June 6, 2023

JN 22007

Subject: **Review of Revised Plans**
Proposed New Residence
6950 Southeast Maker Street
Mercer Island, Washington

JOB NO. 22038
SHEET
C-2

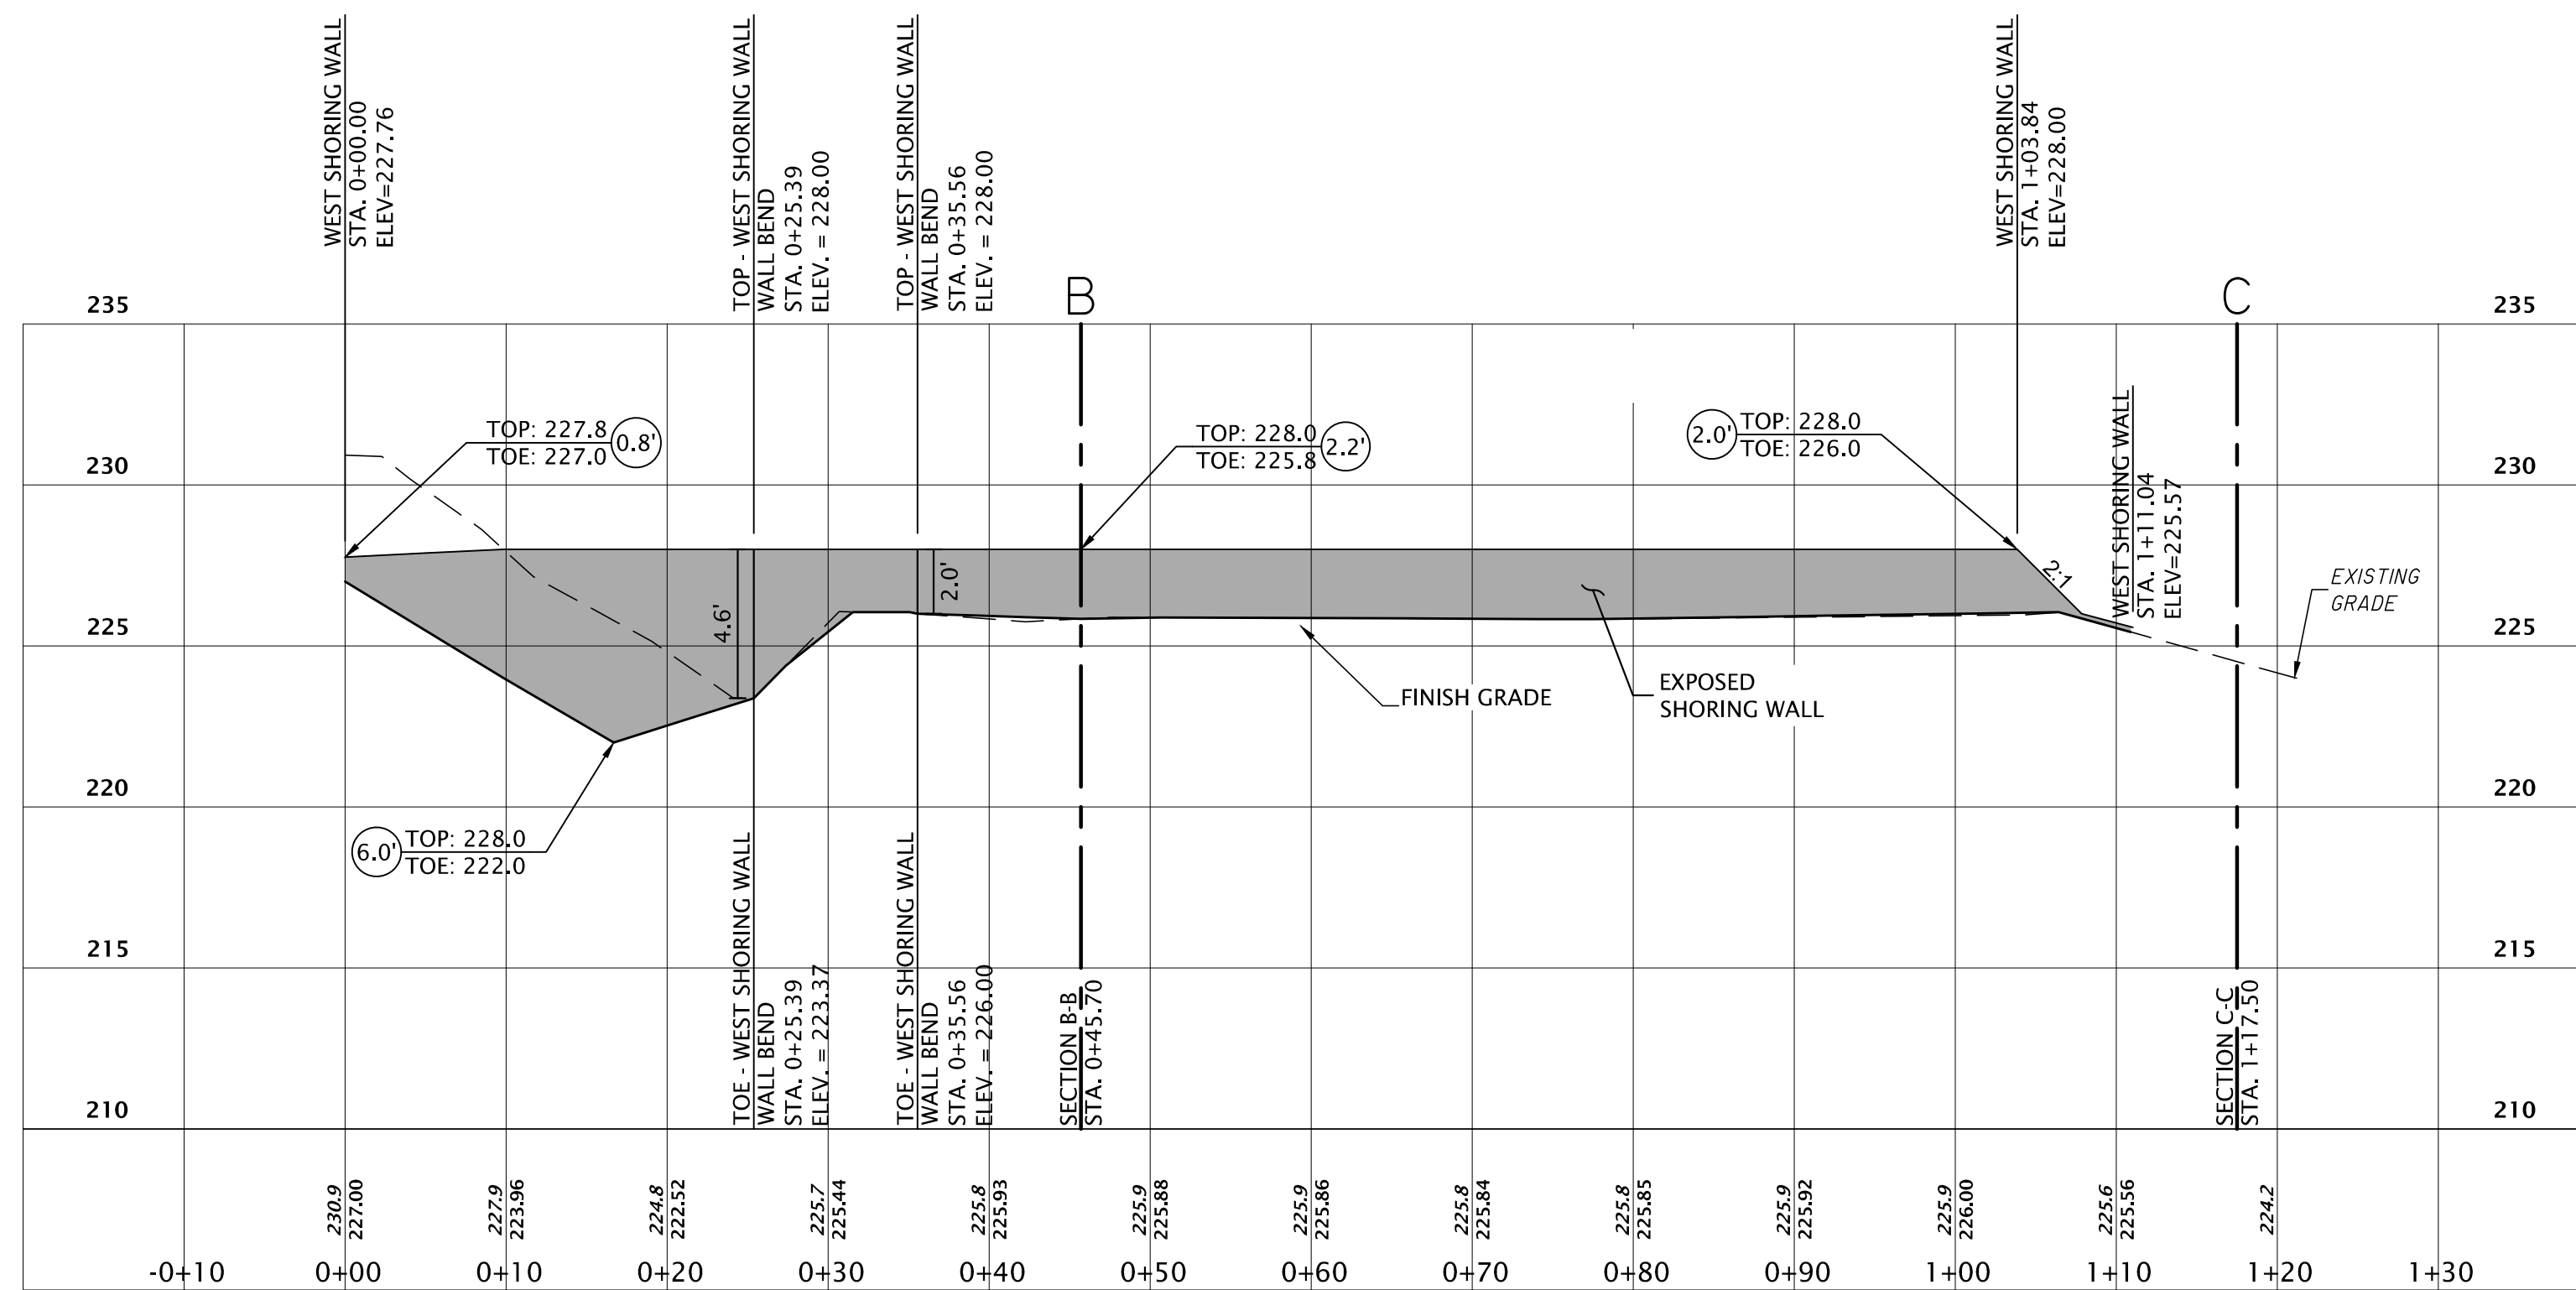
The Site Plan and sections on SH1, as well as sheets C-2 and C-3, properly illustrate the fill berm and modular block wall to be constructed as protection against a potential failure of the eastern neighbor's modular block wall.

Where the new storm outfall pipe will extend to S.E. Maker Street, the existing rockery will be removed, and the ground will be lowered and regraded to a sloping condition between the end of the stabilization wall and the new driveway.
